Online Comment

Application H11-0390-20
Location ADDERLEY HOUSE 23 LONDON ROAD LONG SUTTON PE12 9EA
Proposal Renovation and Change of Use from C2 Residential Care Home to C3 to form 10 Self Contained Residential Apartments

Name Gregory Watkinson, Conservation Officer
Address Council Offices Priory Road Spalding PE11 2XE

DWG TITLE:
Proposed Plans

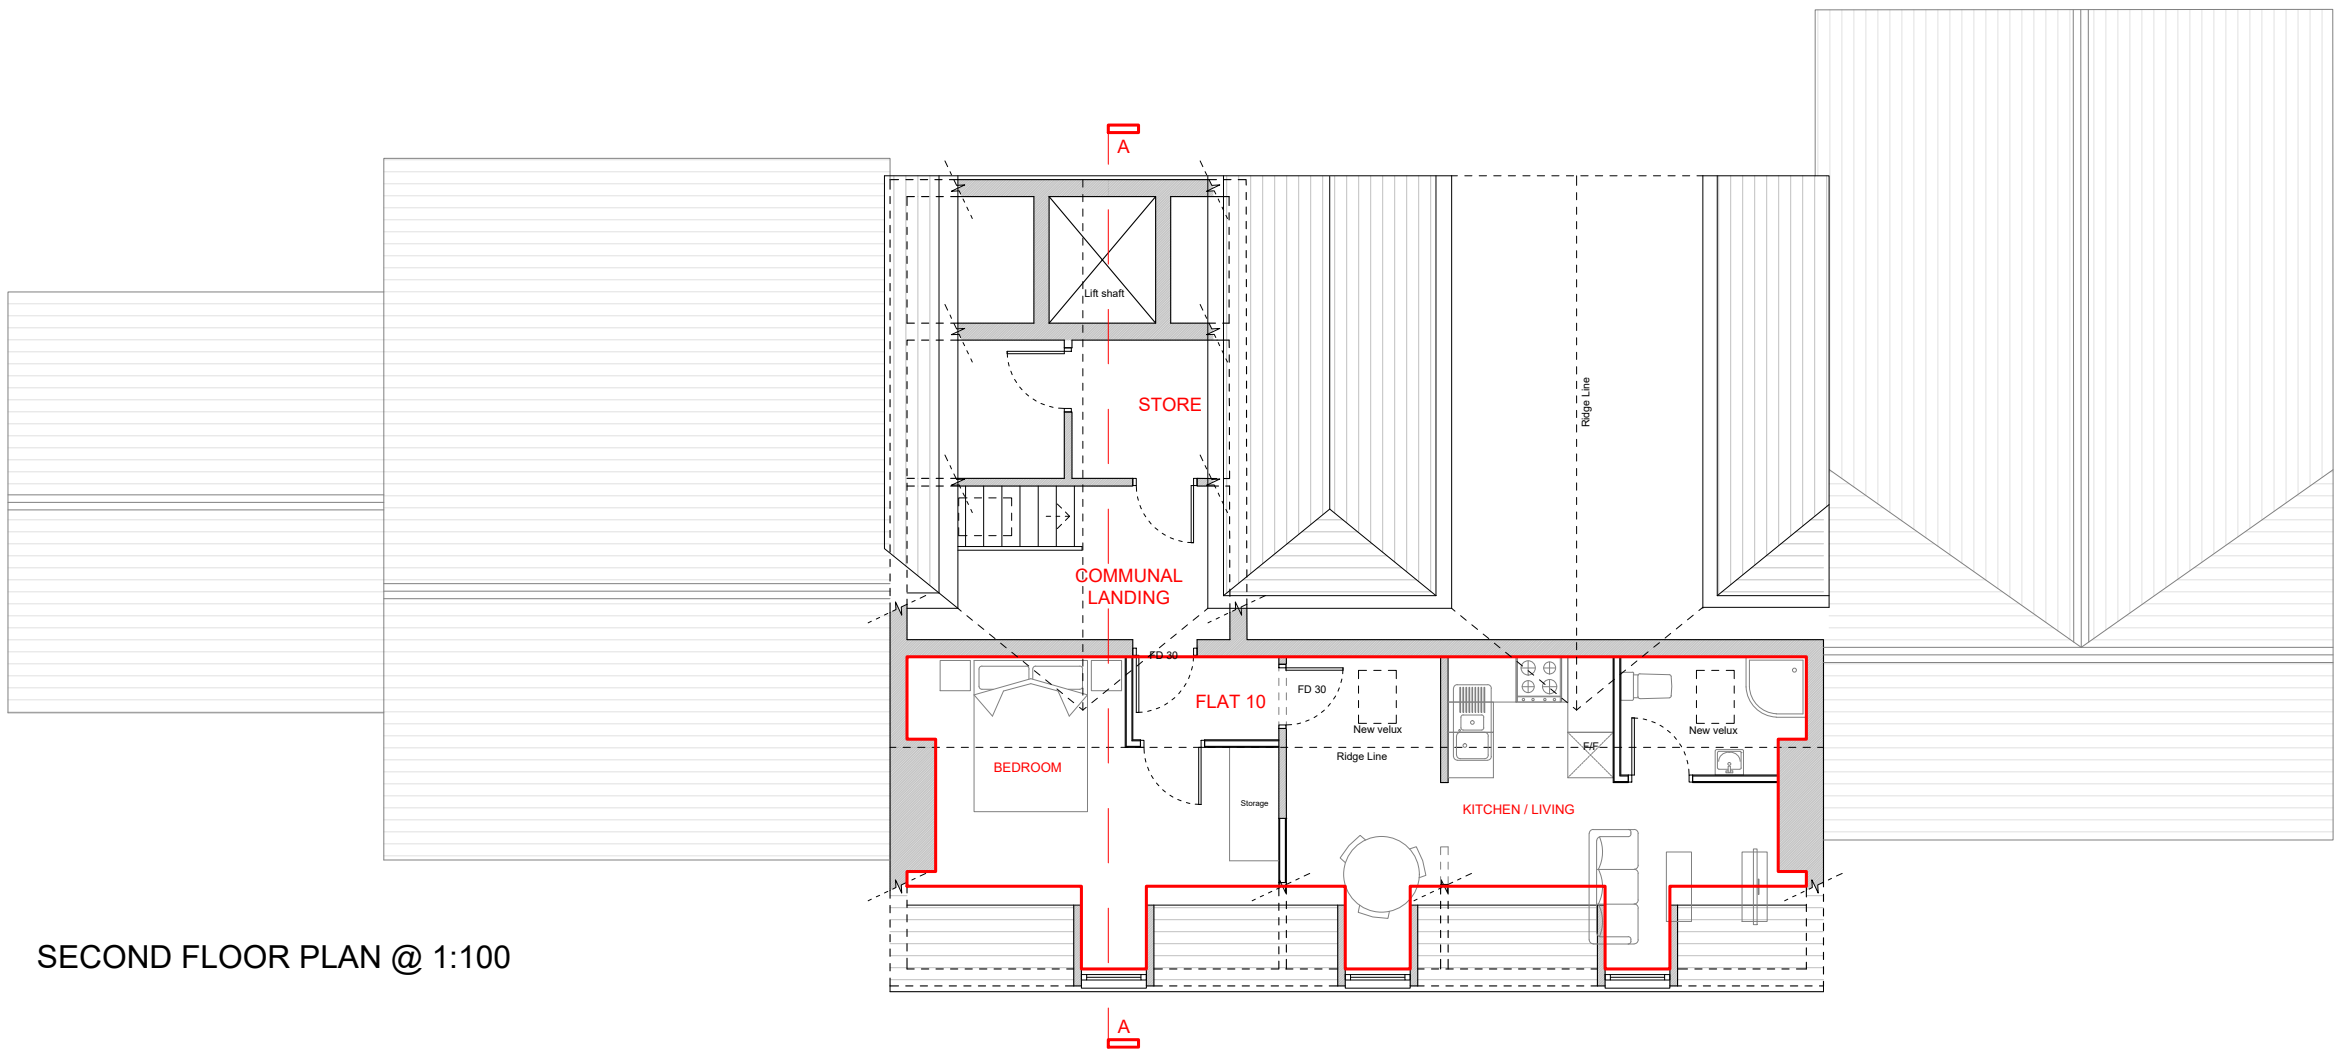
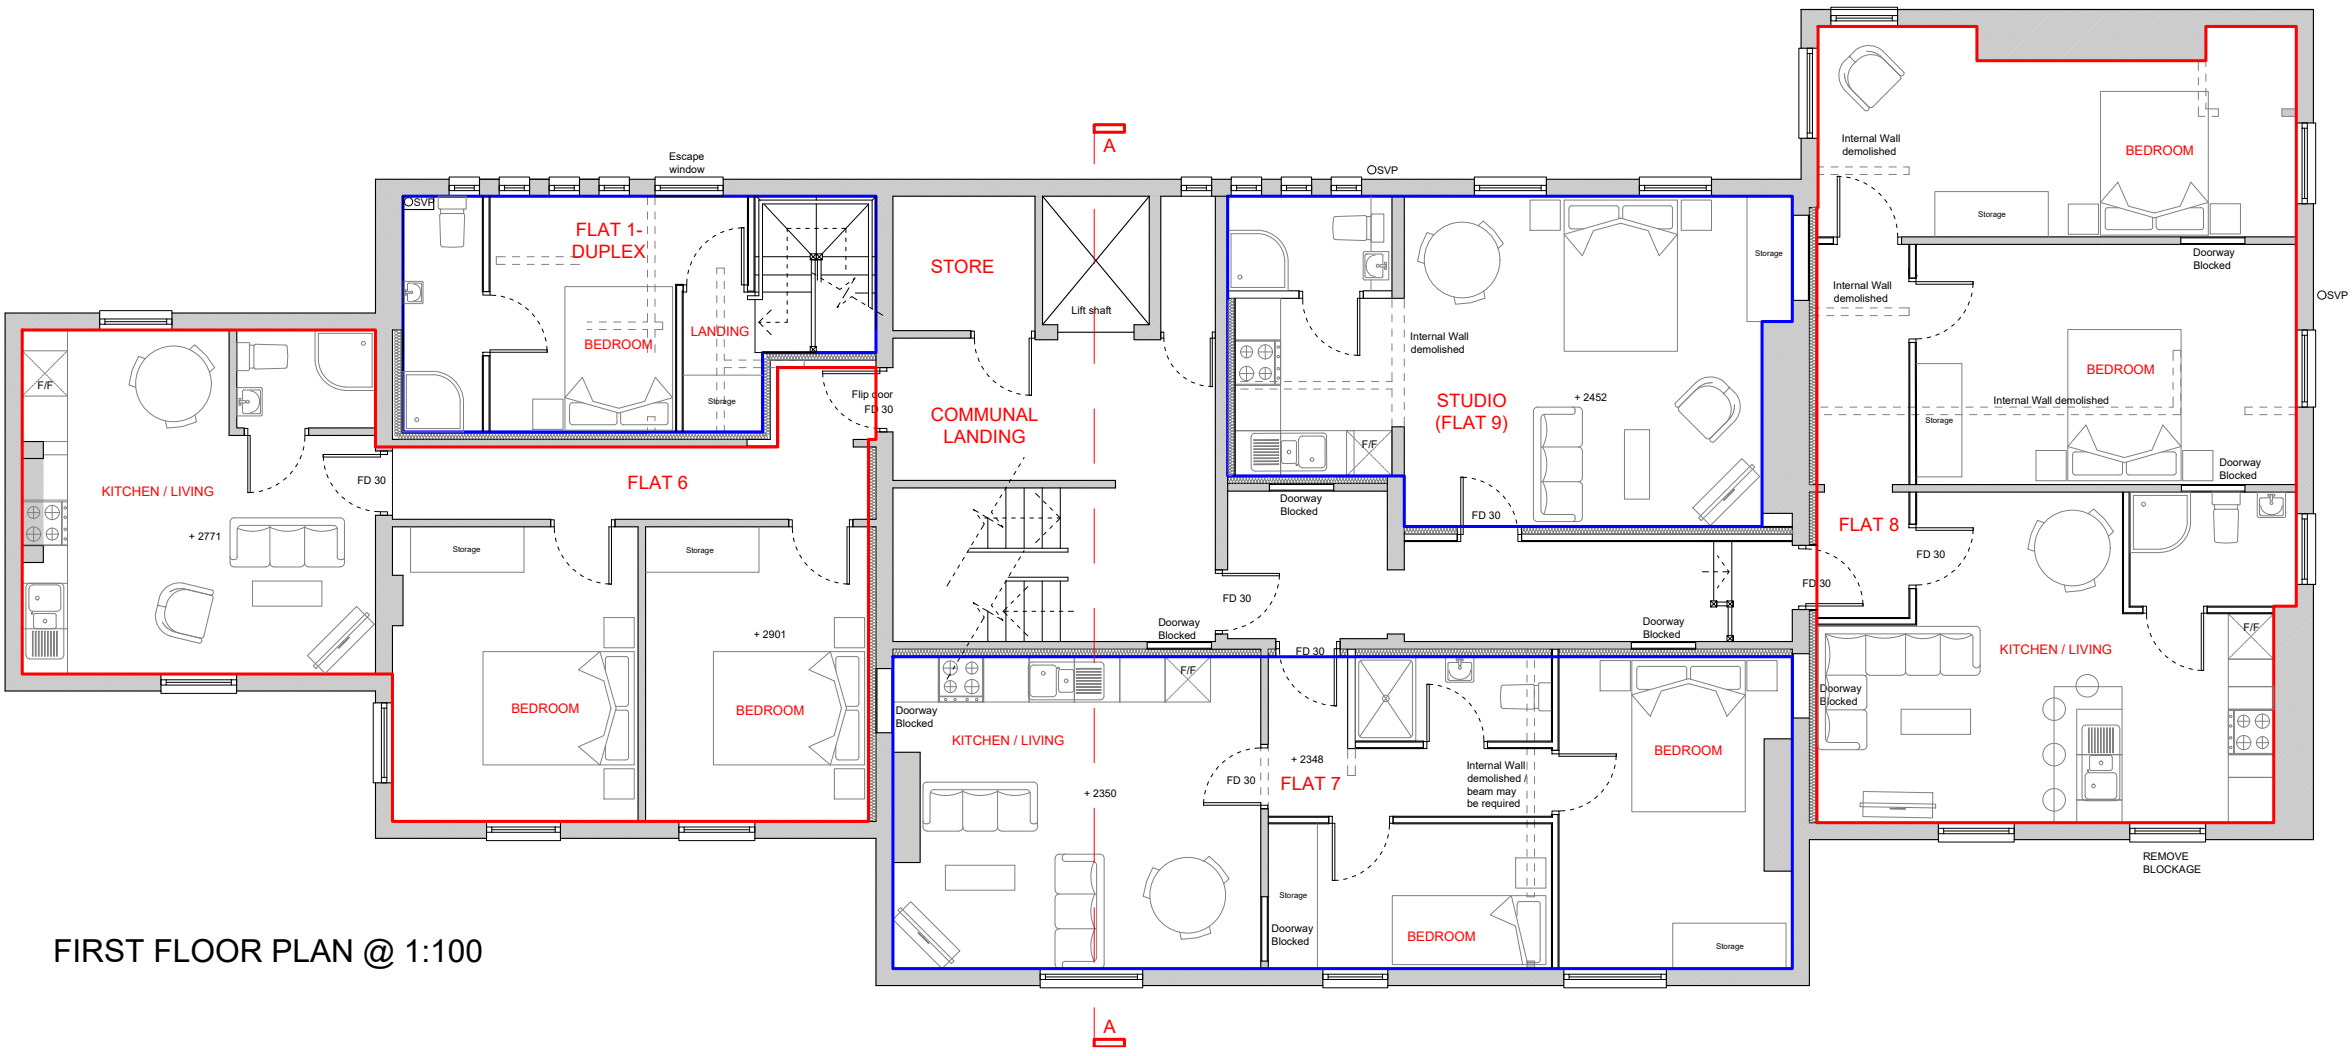
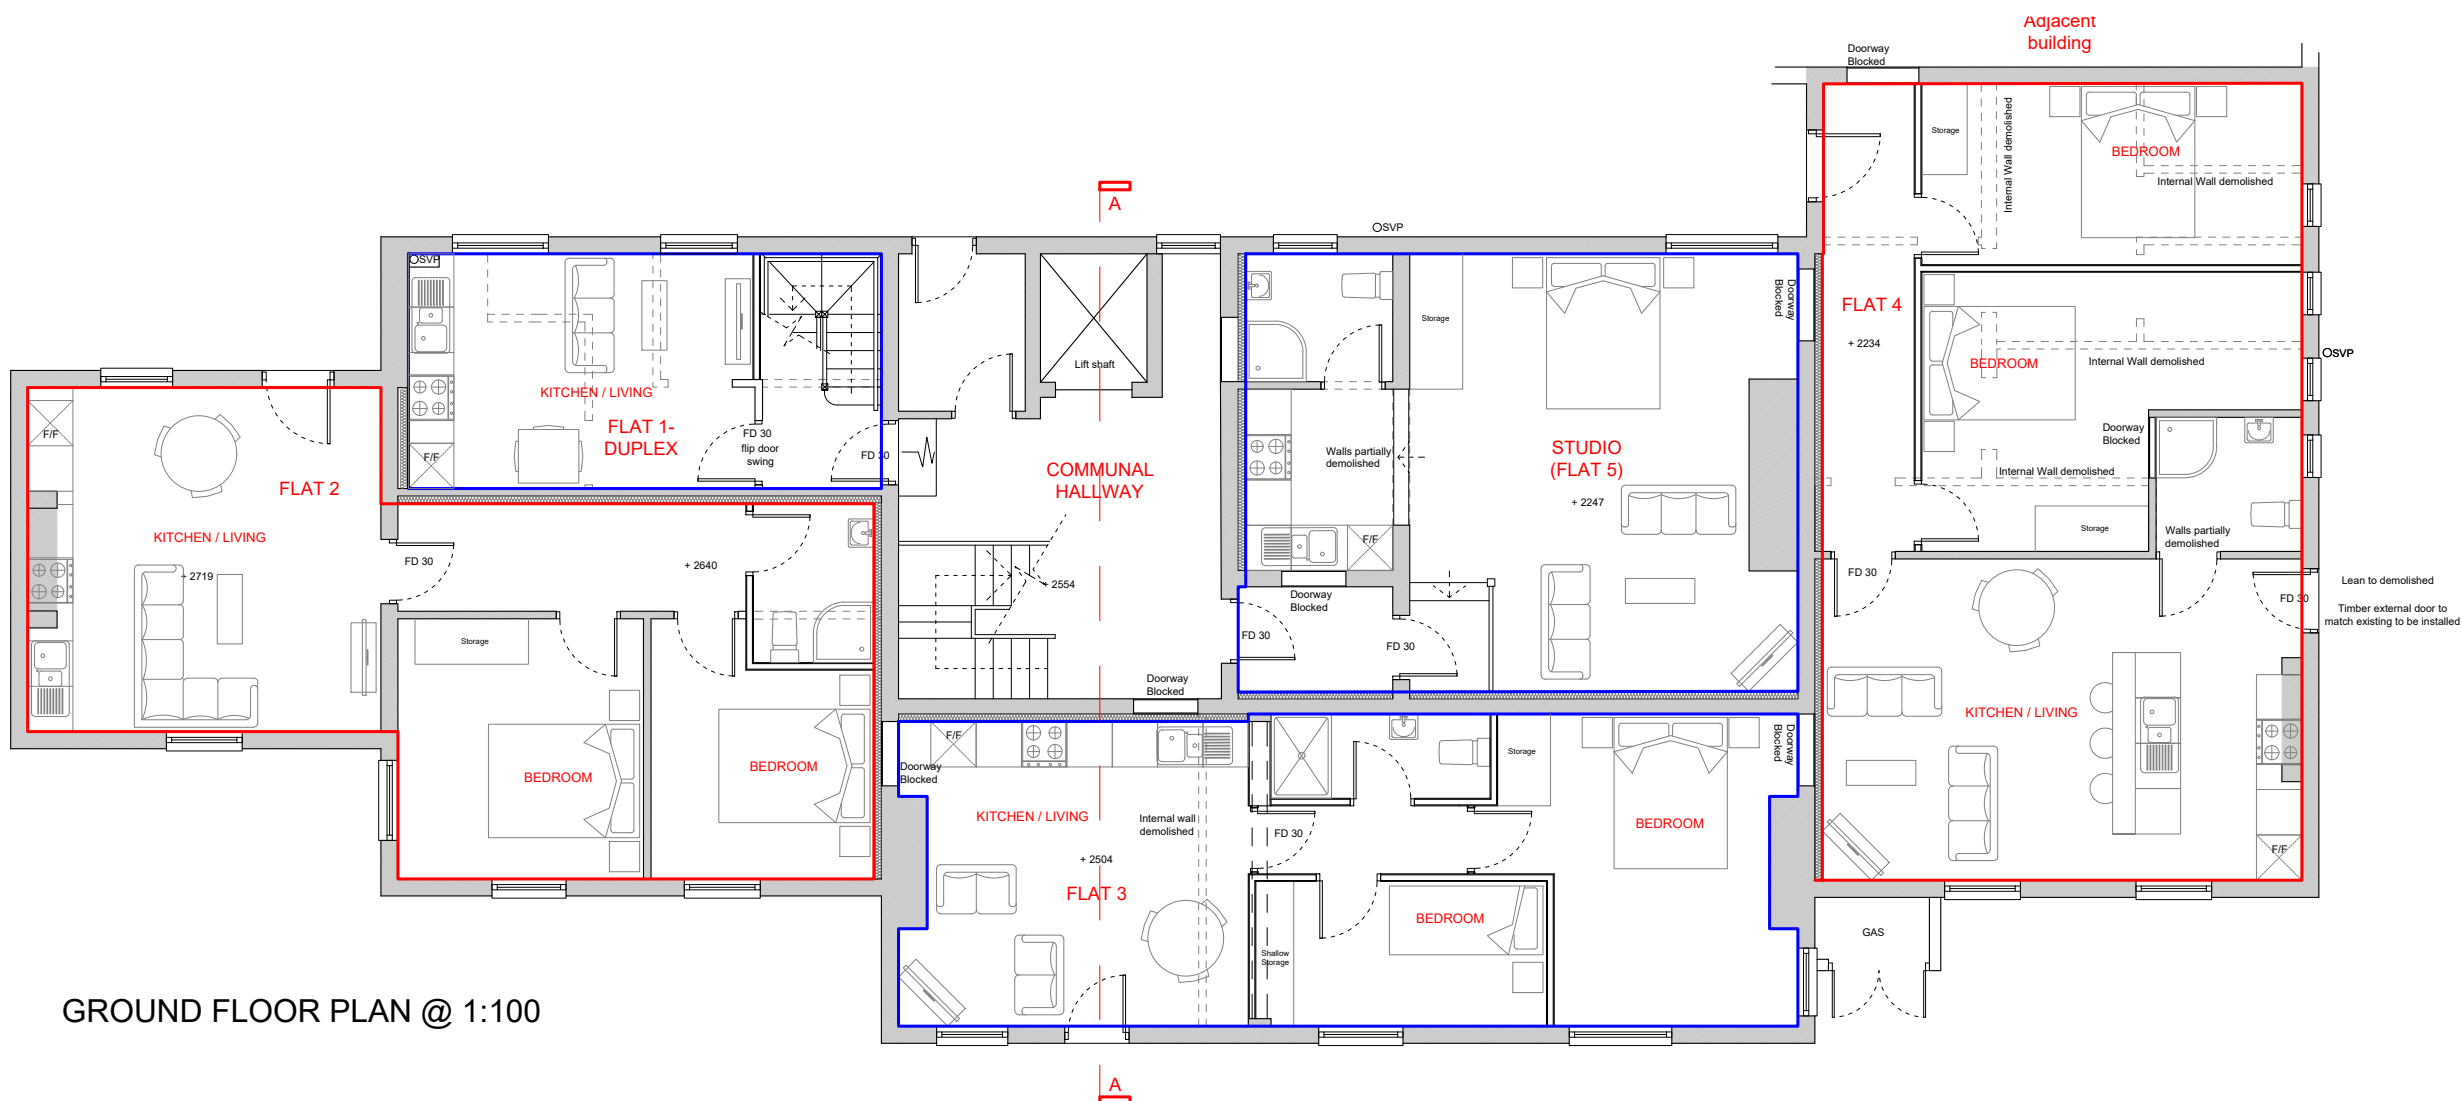
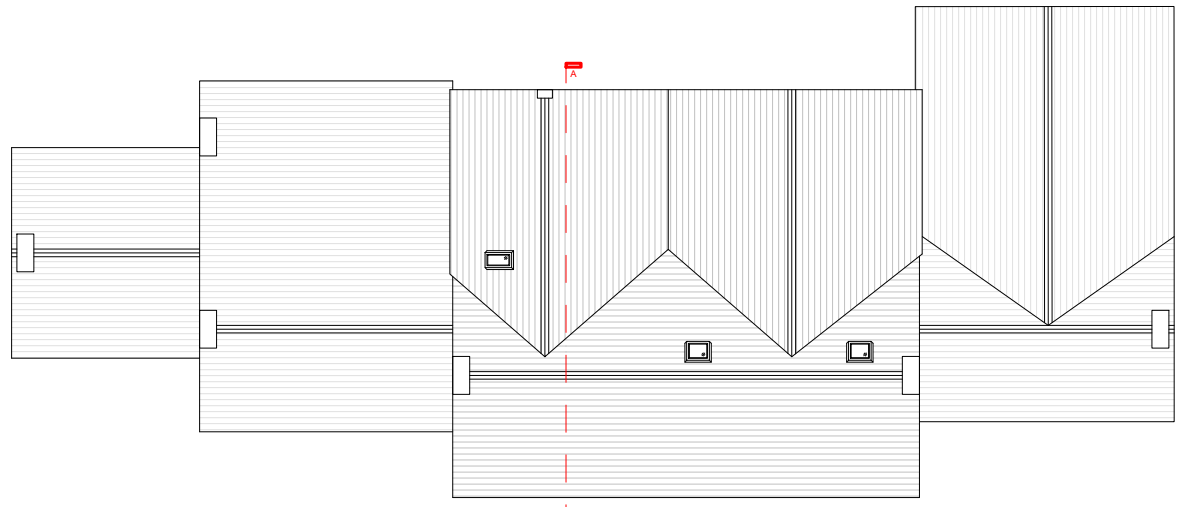
Having reviewed the plans submitted within this application, I wish to raise no concerns with the principle of development in terms of conversion of this listed property from C2 use to C3 use. It is good to see that the proposals to add new walls and divisions would be done in a fully reversible manner, that the new external window on the frontage elevation would be replica in style and timber in construction and also that the proposed roof windows are heritage style units.

Unfortunately, without the benefit of a site visit, i am unaware of the condition of the interior of the property, but the single concern i would raise is that as the property is Grade II listed, the removal of internal material may present a significant risk to the historic value of the property, particularly via the removal of the staircase in the South Eastern wing of the building. Generally it is accepted that removal of original material within listed buildings should be kept to a minimum wherever possible and if the staircase is original to the property or a key character feature of the listing, its loss would not be acceptable.
